Introduction

These comments relate to an outline planning application for up to 500 homes.

- Site boundary 48.846ha (120.70 acres)
- Up to 2 storey (9m)
- Up to 2.5 storey (10m)
- Up to 3 storey (11.5m)
- Up to 3 storey (12.5m) for Use Class E / residential
- Primary street, junction and link to Park View
- Proposed park and ride

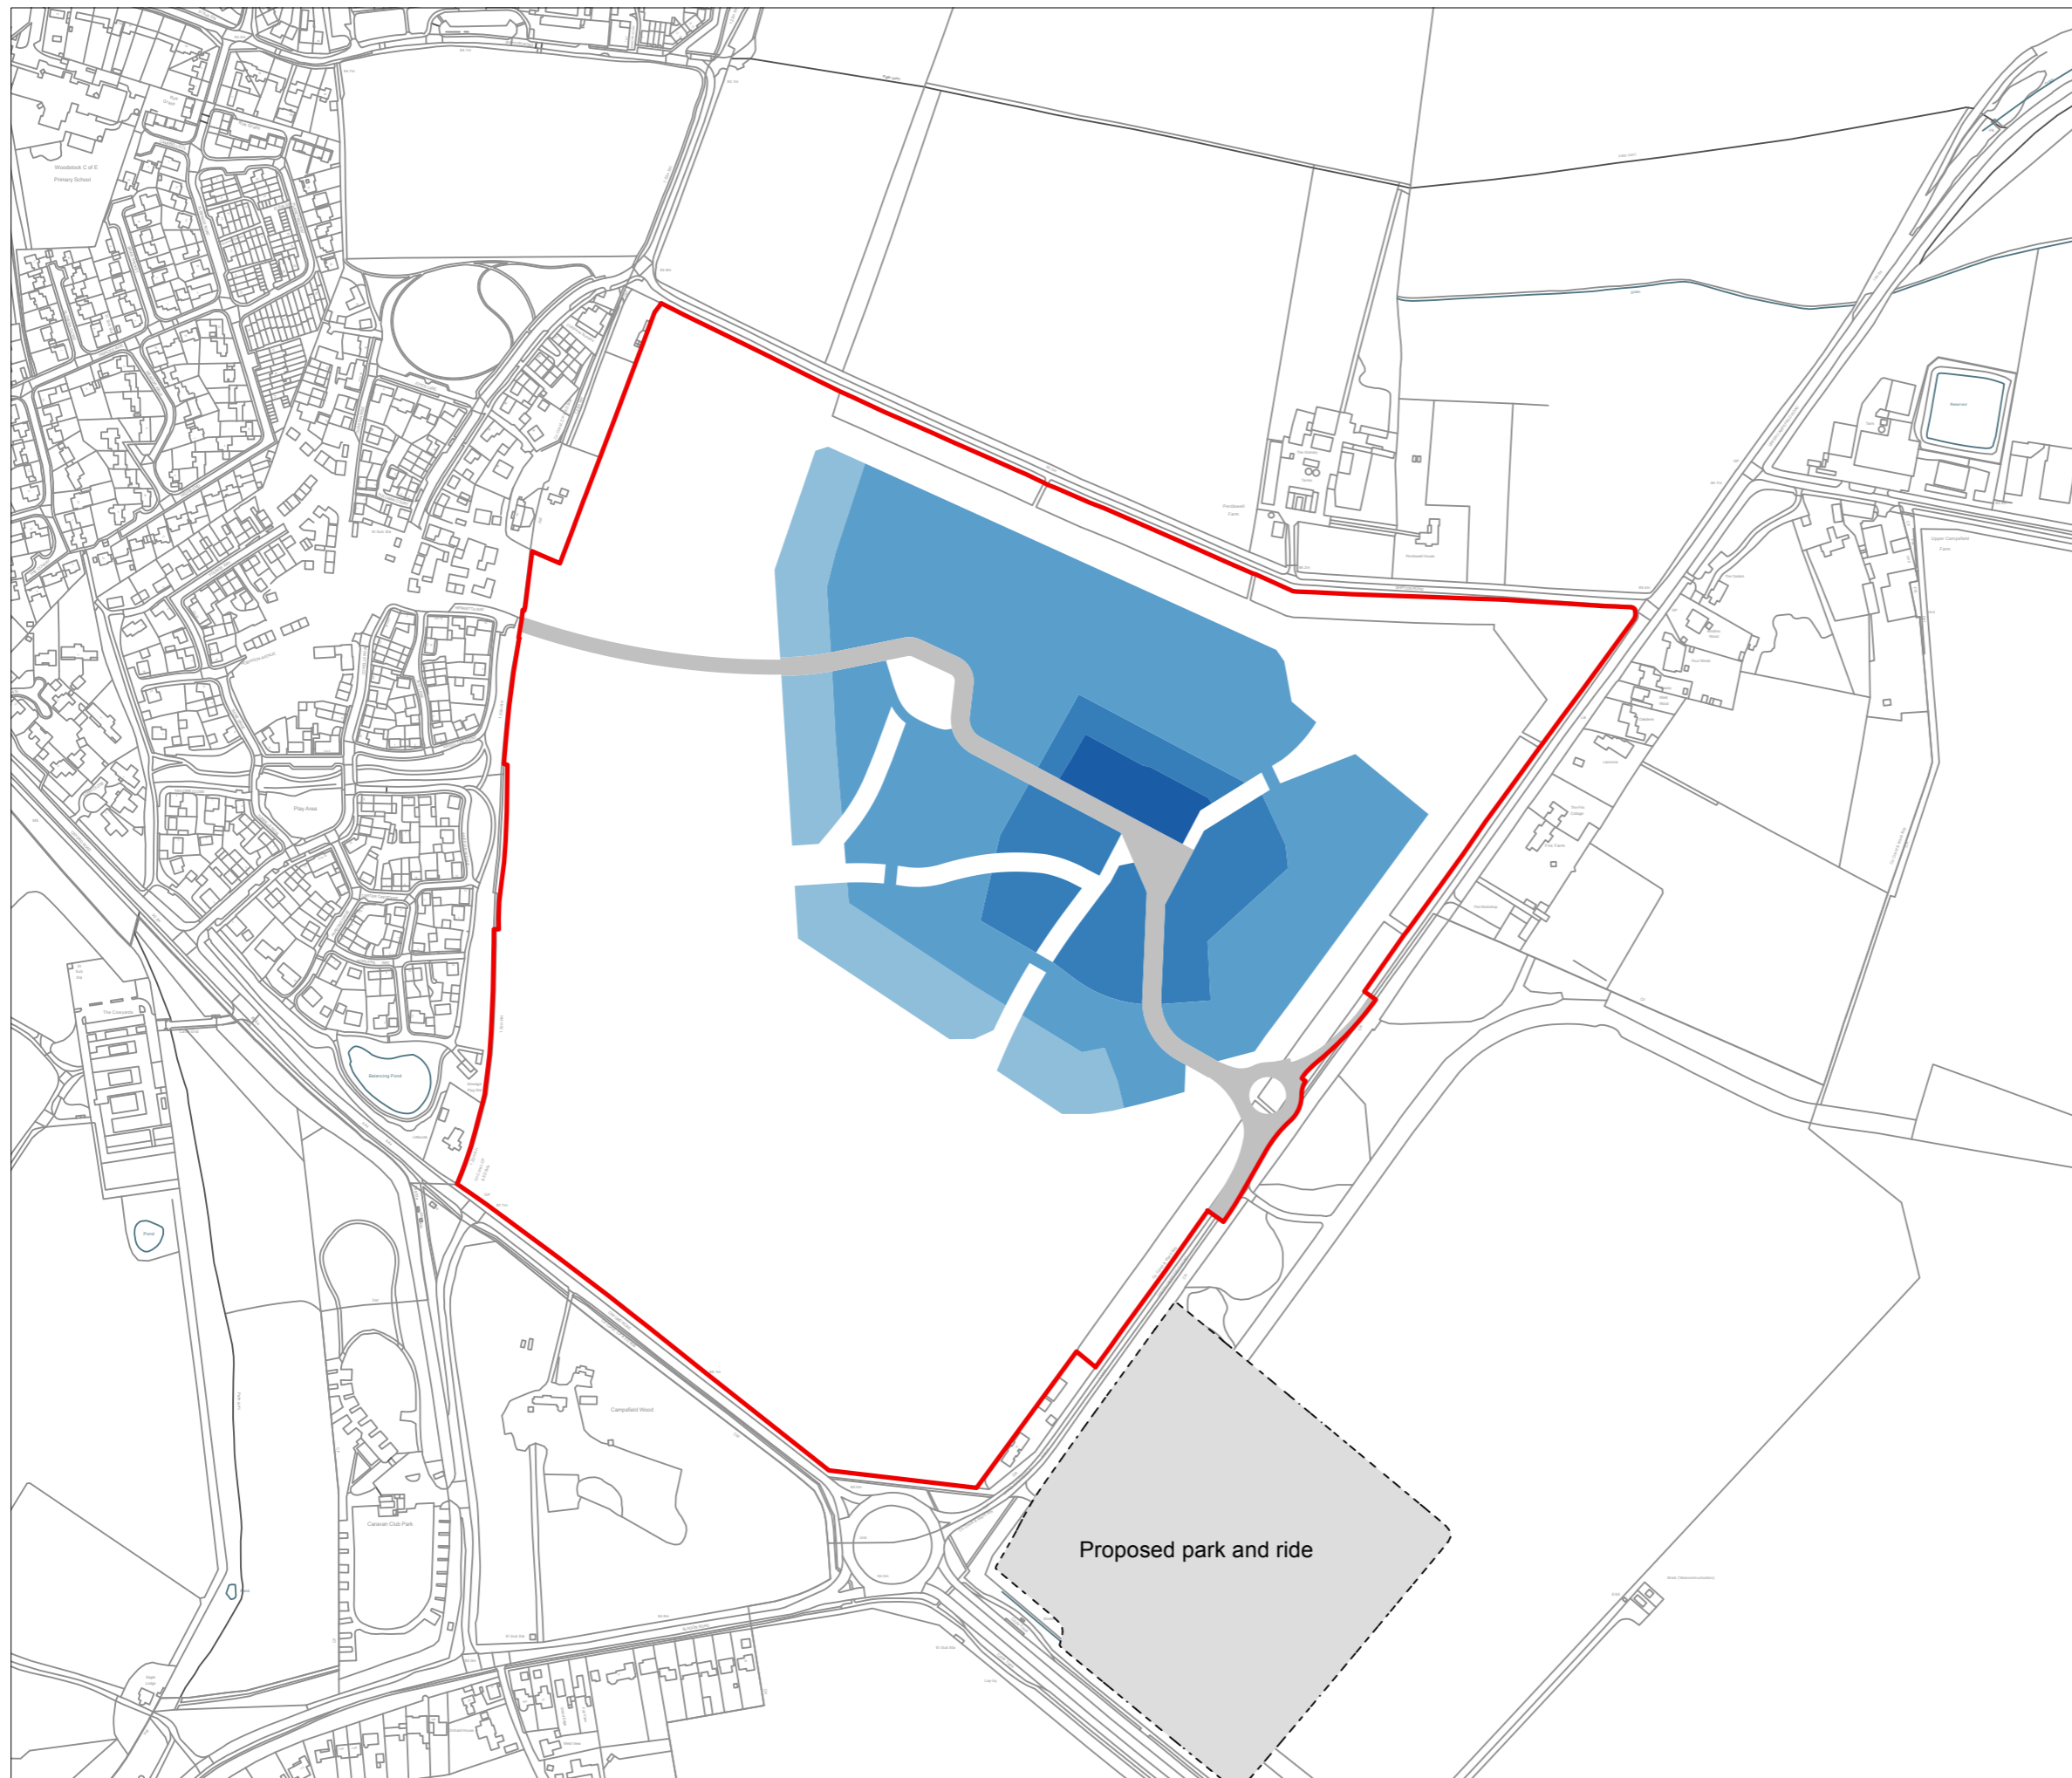
I'm not convinced it will be appropriate for the remaining site areas to be – up to 2.5 storey. The Cherwell Residential Design Guide requires dormers to be used sparingly.

I suggest the parameter includes a note to specify how 2.5 storey development would be used within the scheme or a percentage i.e. for specific urban design reasons such as to mediate between 3 and 2 storey development, waymarker buildings etc.
